<p>Document and Applicants Reference (Examination Library Reference)</p>	<p>Comment</p>
<p>Highways England – Deadline 1 Submission - 6.7 Appendix 2.1 Lighting Assessment - Rev 1 (REP1-011)</p>	<p>Noted the reasoning behind not introducing lighting throughout the route. Notwithstanding any future reconsideration that there may yet be on safety grounds, this decision is welcomed from the point of view of emerging Local Plan Policy ENV 4 regarding the maintenance of dark skies in open countryside areas, especially within the zone of influence of the Dark Sky Park and the AONBs. Should there be any reconsideration of the lighting issue, any lighting introduced should follow lighting design guidance referred to in Policy ENV 4.</p>
<p>Highways England – Deadline 1 Submission - 6.22 Noise Addendum - Rev 0 (REP1-019)</p>	<p>In Table 1-4 – Local Planning Policy Relevant to Noise, the relevant Local Plan and Core Strategy policies seem to be satisfactorily addressed.</p>

<p>Highways England – Deadline 1 Submission - 7.8 Applicant’s Response to ExA’s First Written Questions - Rev 0 (REP1-032)</p>	<p>GEN1.8 We consider that the introduction of a footway/cycleway along the full length of the

Corrected Figure 32 of the Case for the Scheme

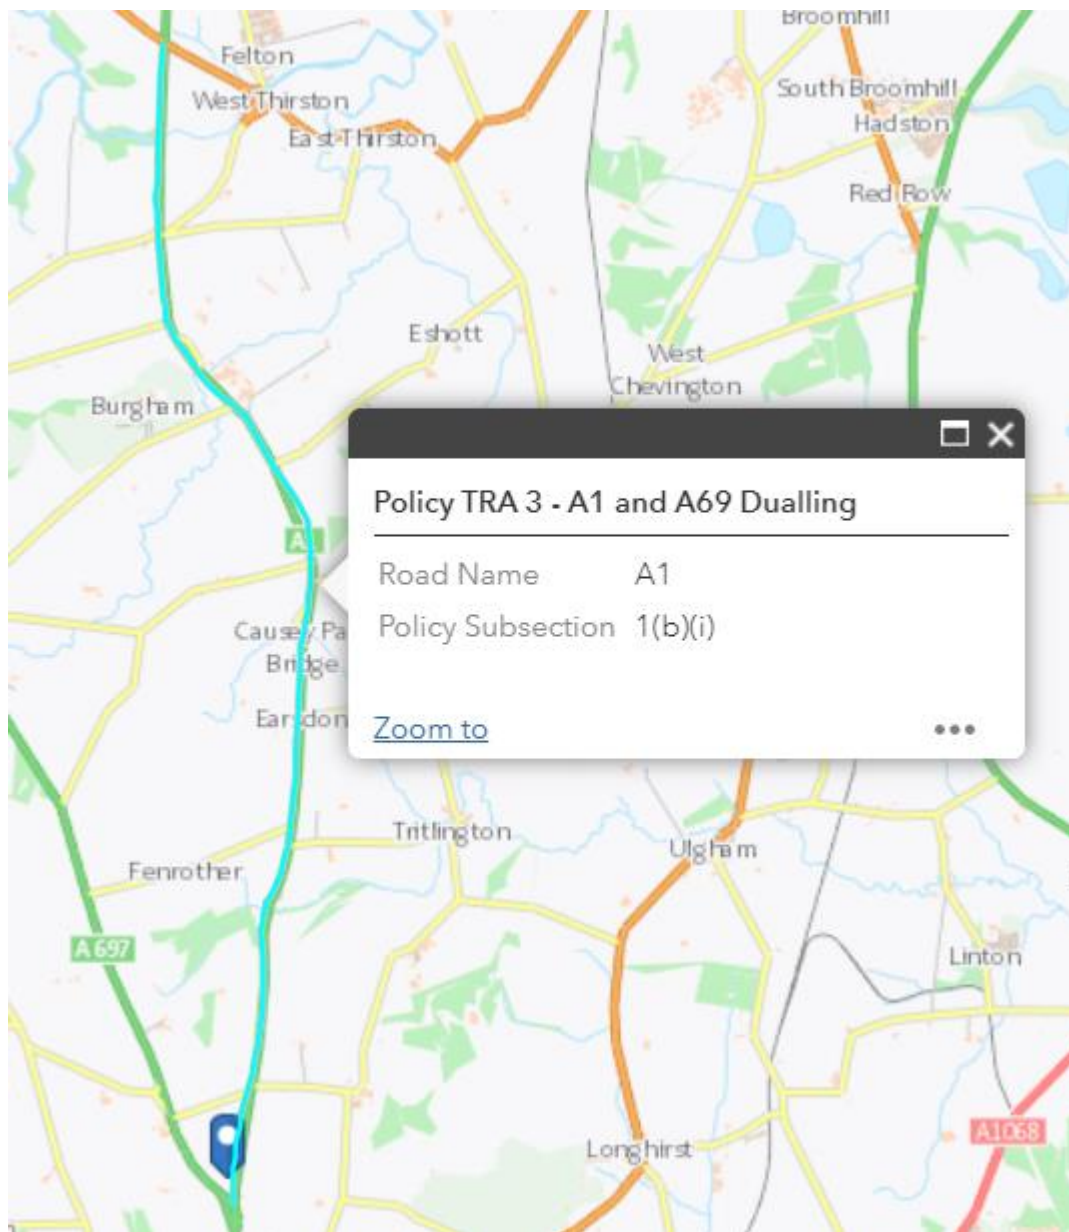
Highways England – Deadline 1 Submission – 7.8.22 Tree Protection plan and Composite Table (REP1-052)	Improved tree removal and protection plans, not reviewed in detail, but far more informative and user-friendly than previous plans
Highways England – Deadline 1 Submission - 7.8.32 Appendix GEN.6 - Figure 32 WQ GEN.1.28 - Rev 0 (REP1-062)	Noted
Highways England – Deadline 1 Submission - 7.9 Applicant’s Response to Relevant Representations - Rev 0 (REP1-064)	1.2 LOCAL AUTHORITIES Table 1-1 - Northumberland County Council – RR-001 1.1.2 The response here sets out a comprehensive explanation of the community

**Trees to be Removed and Replaced at Coronation Avenue  
WQ LV.1.8**

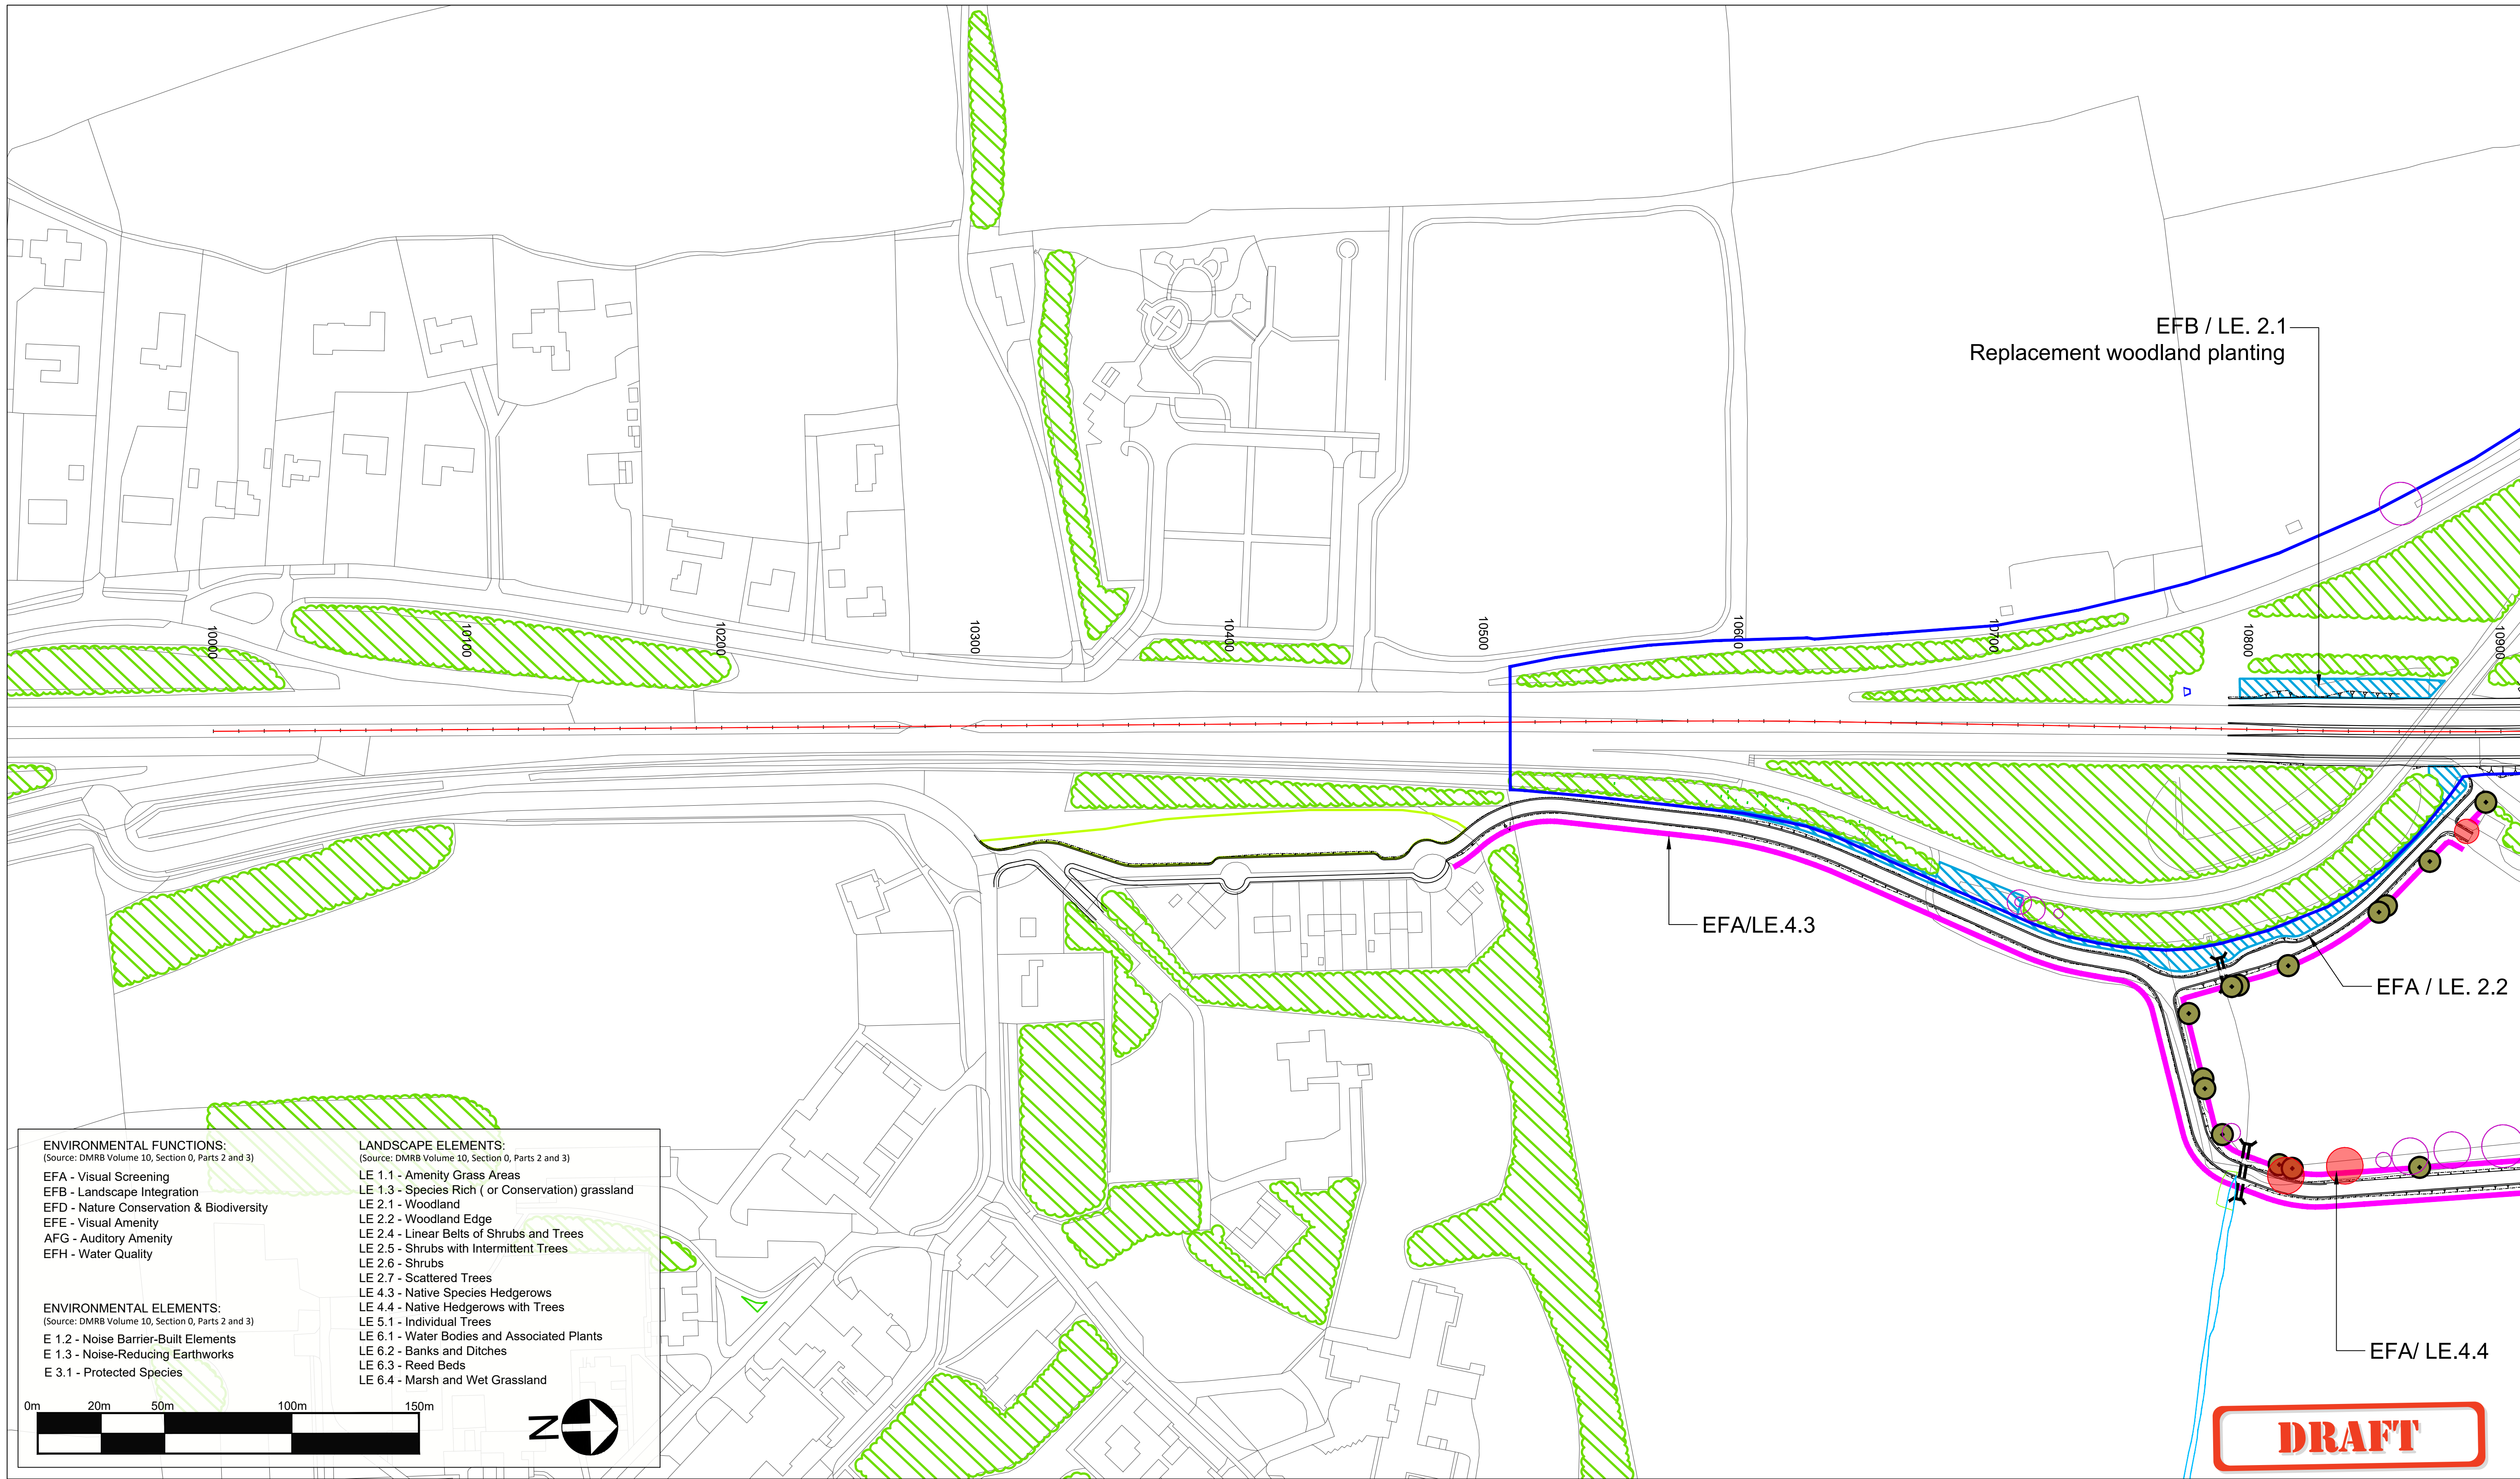
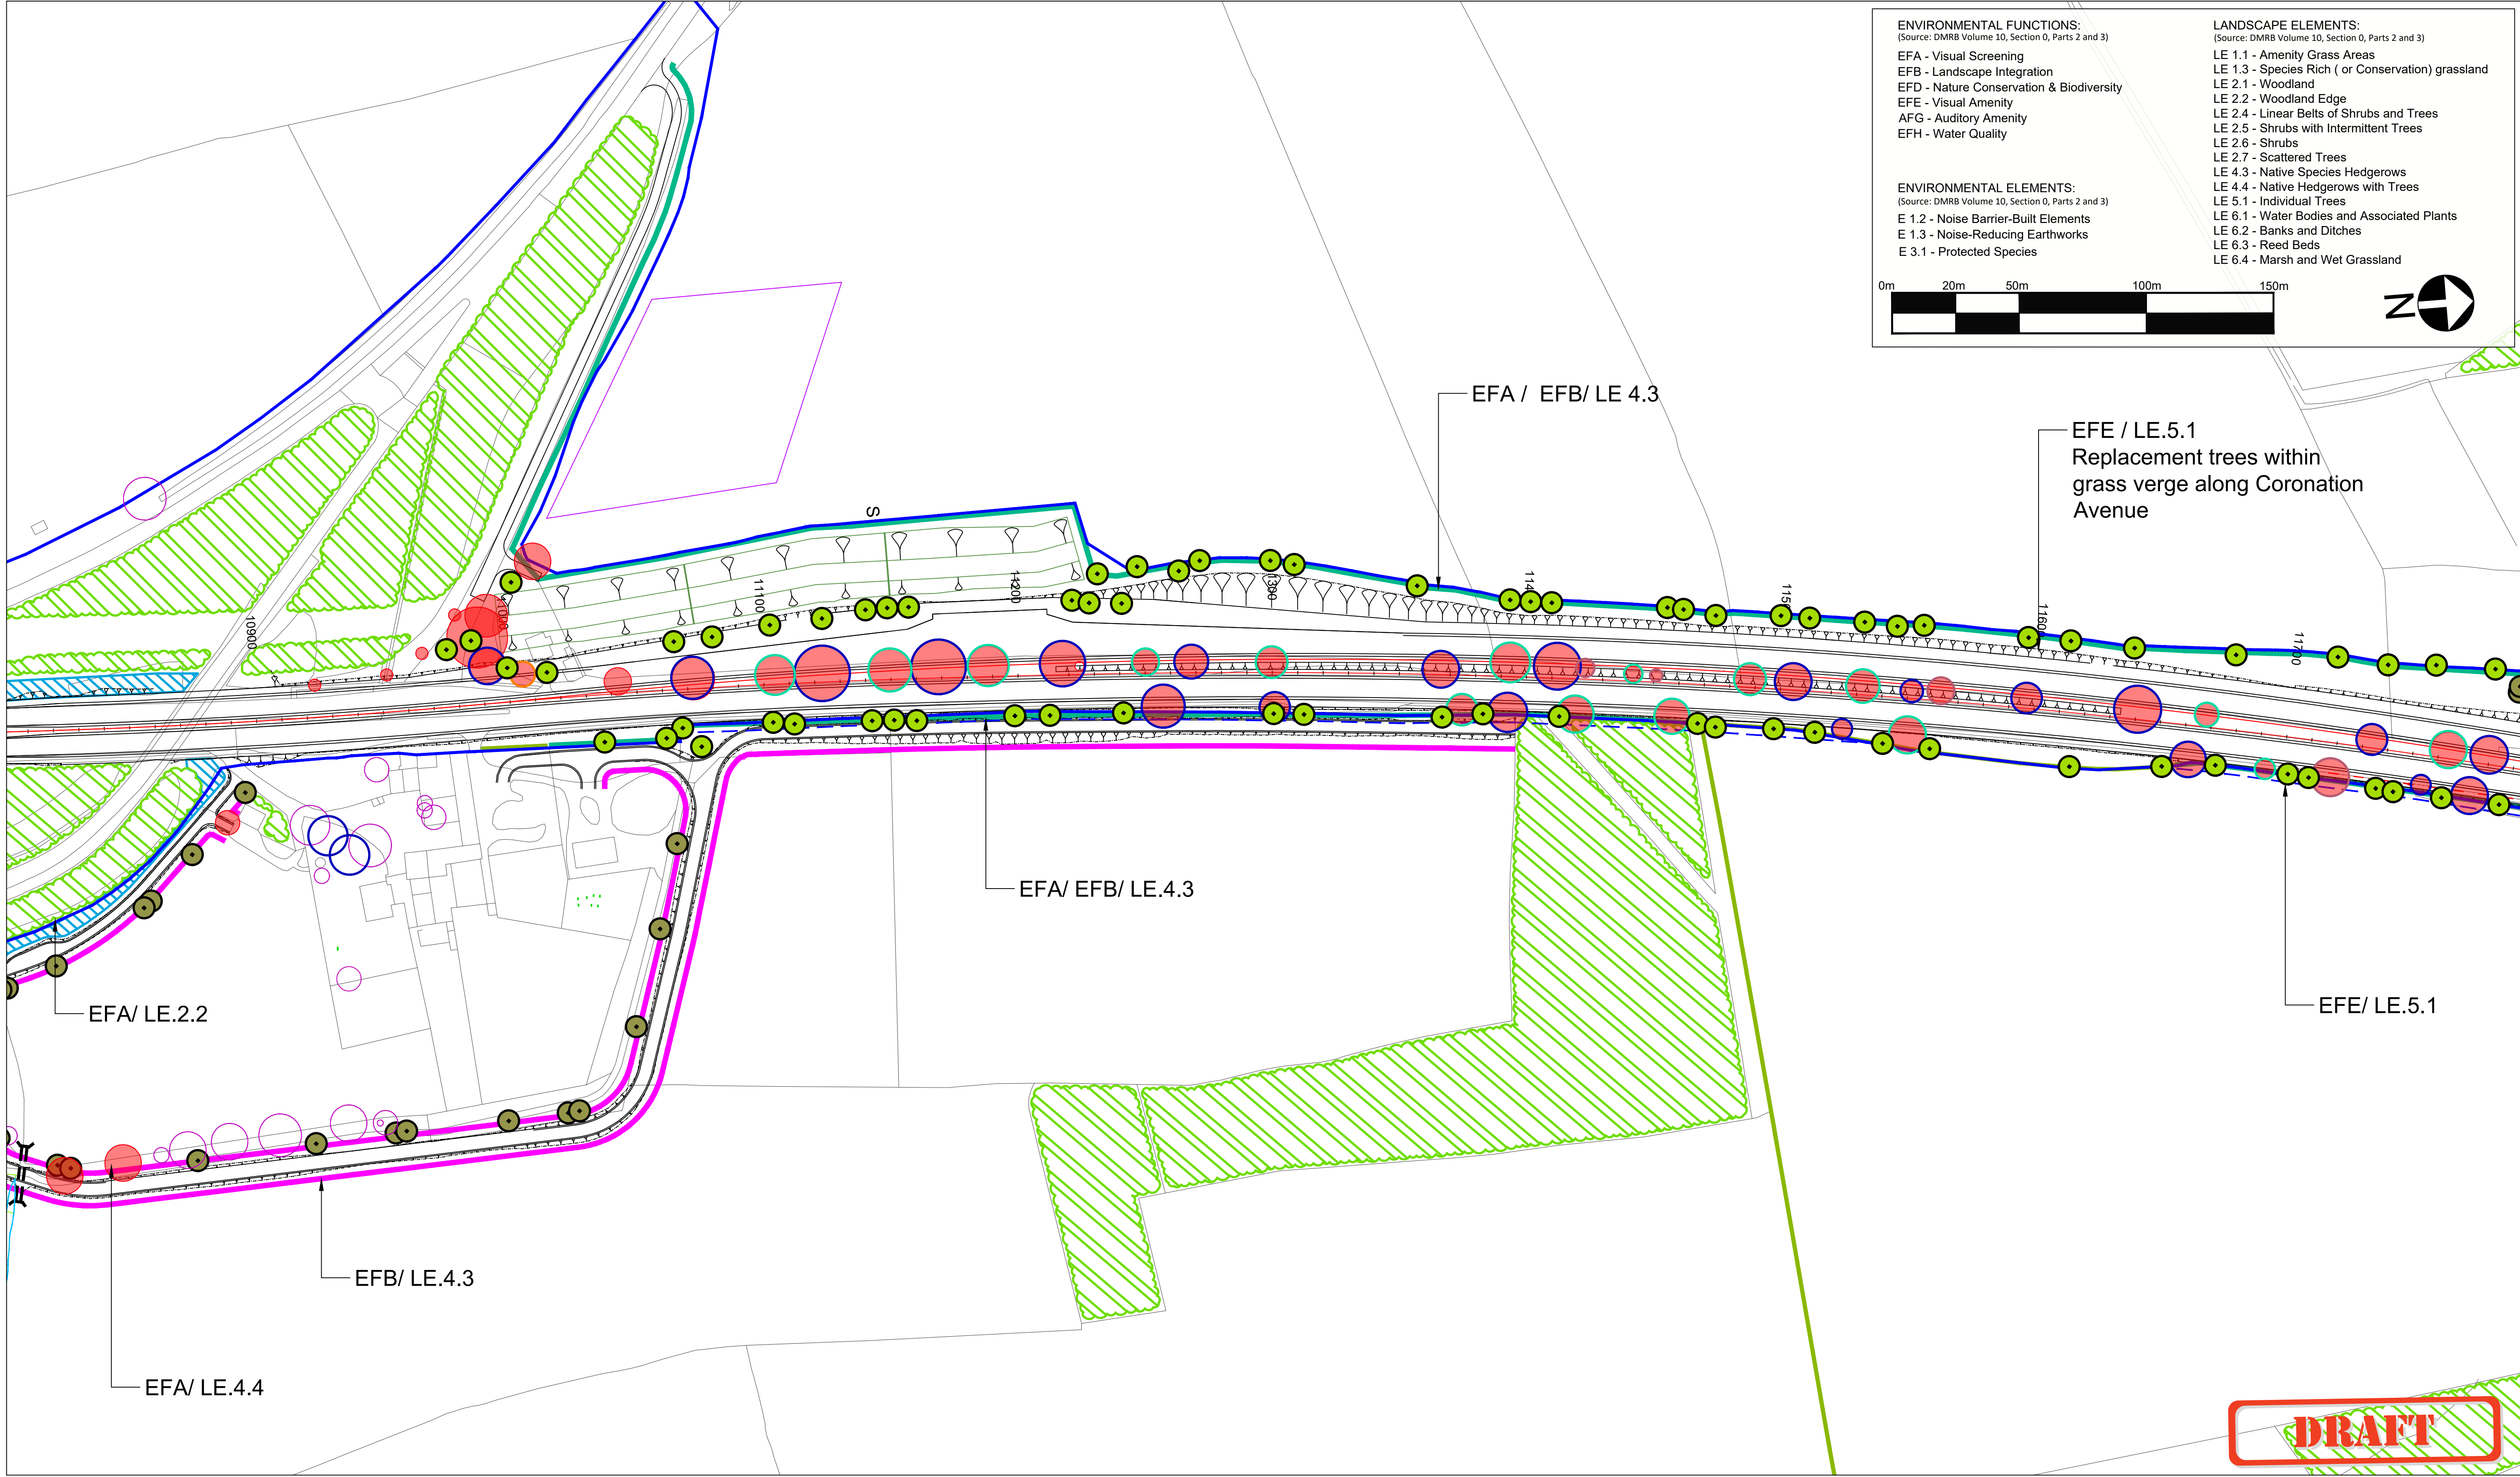
Document and Applicants Reference (Examination Library Reference)	Comment
Highways England – Deadline 1 Submission - 7.8.13 Appendix LV.2 Trees to be removed and replaced at Coronation Avenue (REP1-044)	As previously reviewed and agreed
Highways England – Deadline 1 Submission - 7.8.20 Appendix LV.1 Summary Table (REP1-050)	The schedule of vegetation removals has not been reviewed in detail. Will be discussed with applicant as part of Statement of Common Ground discussions.
Highways England – Deadline 1 Submission -7.8.21 Appendix LV.3 response to WQ LV 1.1.13 (REP1-051)	This document provides a specific response regarding potential further mitigation for significant effects on residential receptors. Several of these coincide with community receptors at West Moor (R35, R36 and R37) and Causey Park Bridge (R58 and R59) for which we have been requesting further consideration and mitigation (see above) and still consider despite the response given that improvements to mitigation could be made. Discussions with the applicant are ongoing on this matter
